Variation of a condition application

Meadow Lea Cottage, 14 Church Street, Stiffkey, NR23 1QJ Original planning permission ref: PF/20/1518, granted 19/01/21

EX 03A

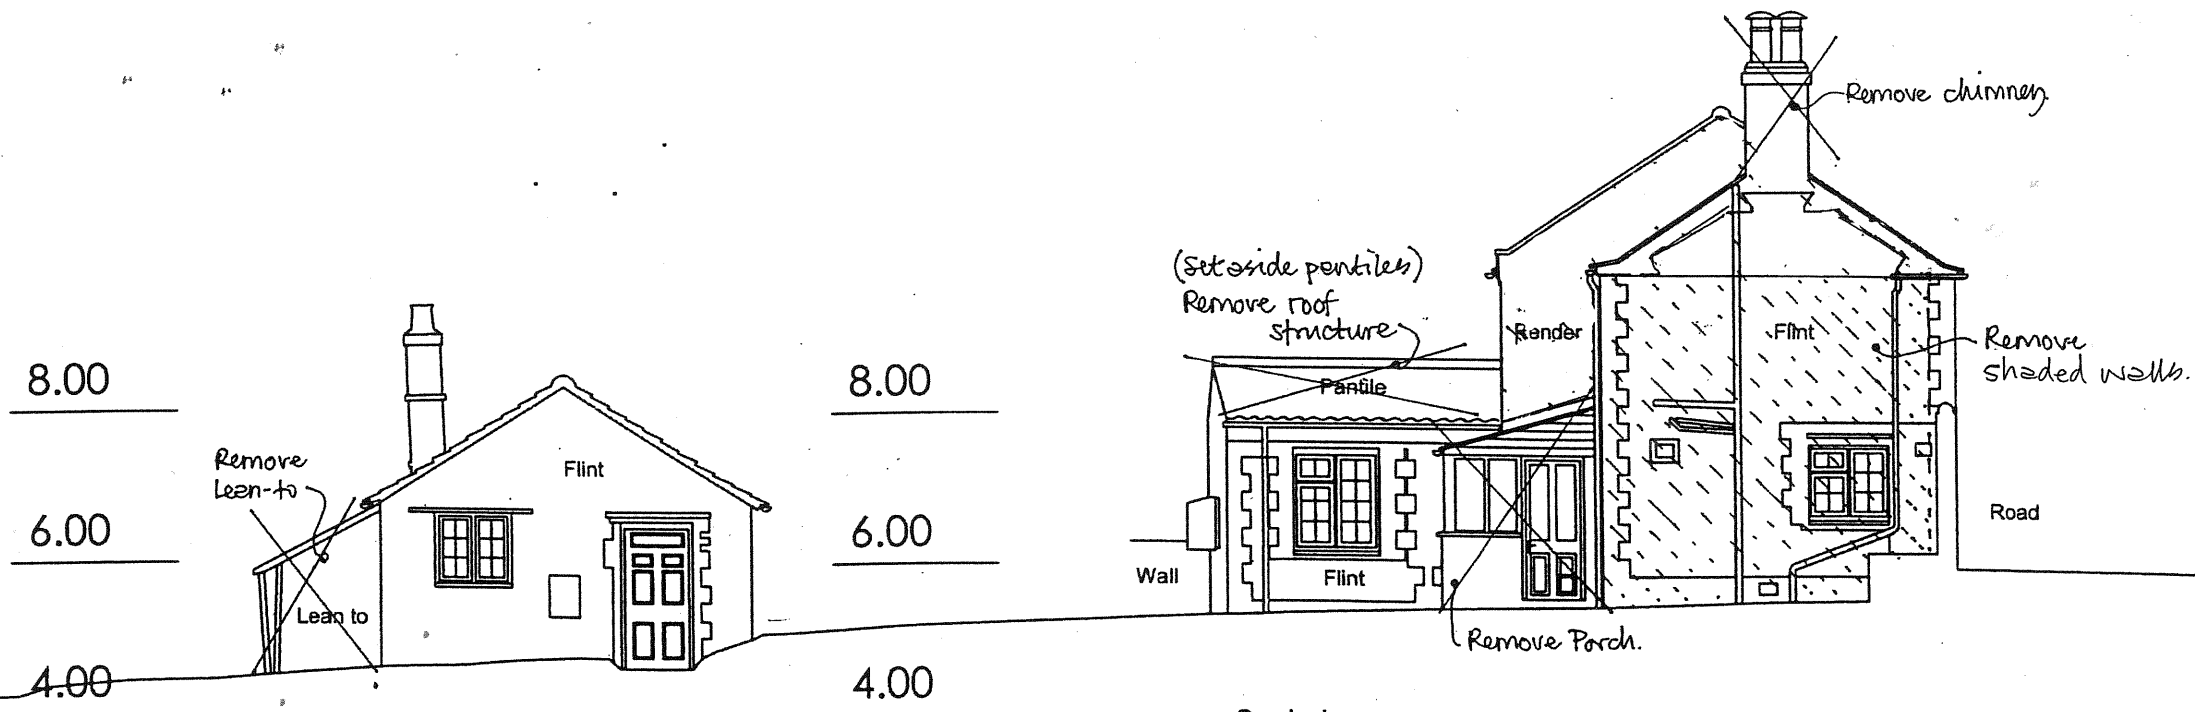
We have hatched the walls to be removed onto the attached existing plans, so it is clear to see what work is necessary to realise the permission. These are noted 'Extg drwgs showing permitted demolition' and consist of three drawings, EX 01A, EX 02A & EX 03A.

EX 03 B

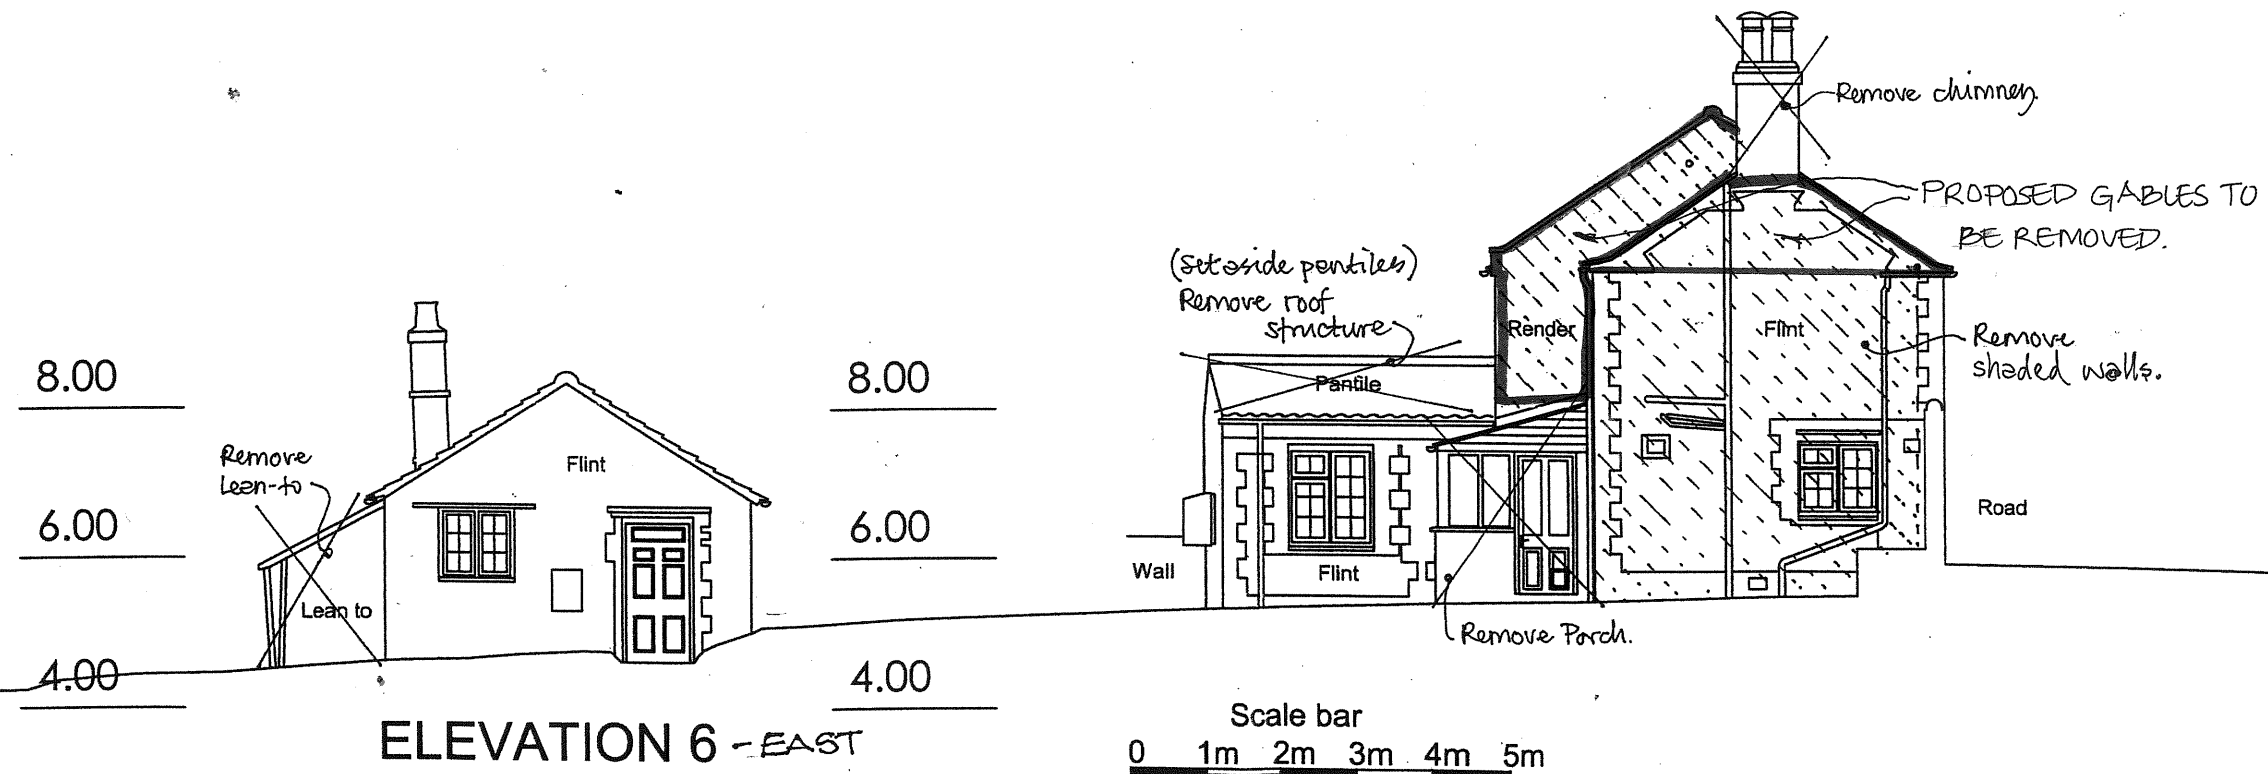
EX 01B shows the area of the rear wall at first floor level, which we would now like to remove. EX 02B shows the rear elevation, with the area of wall outlined in black. EX 03B shows the side elevation with the top of the two East gables outlined in black.

The area of the wall & gable to the mid-section of the cottage, we would like to remove is 7.72m sq. The area of the wall & gable to the lower part of the cottage, we would like to remove is 8.94m². The total area is 16.66m sq.

The walls we propose to remove would be reinstated in exactly the same position, in order to maintain the form of the roof structure over. This is reflected in our proposed plans & elevations, originally submitted, which has planning permission.
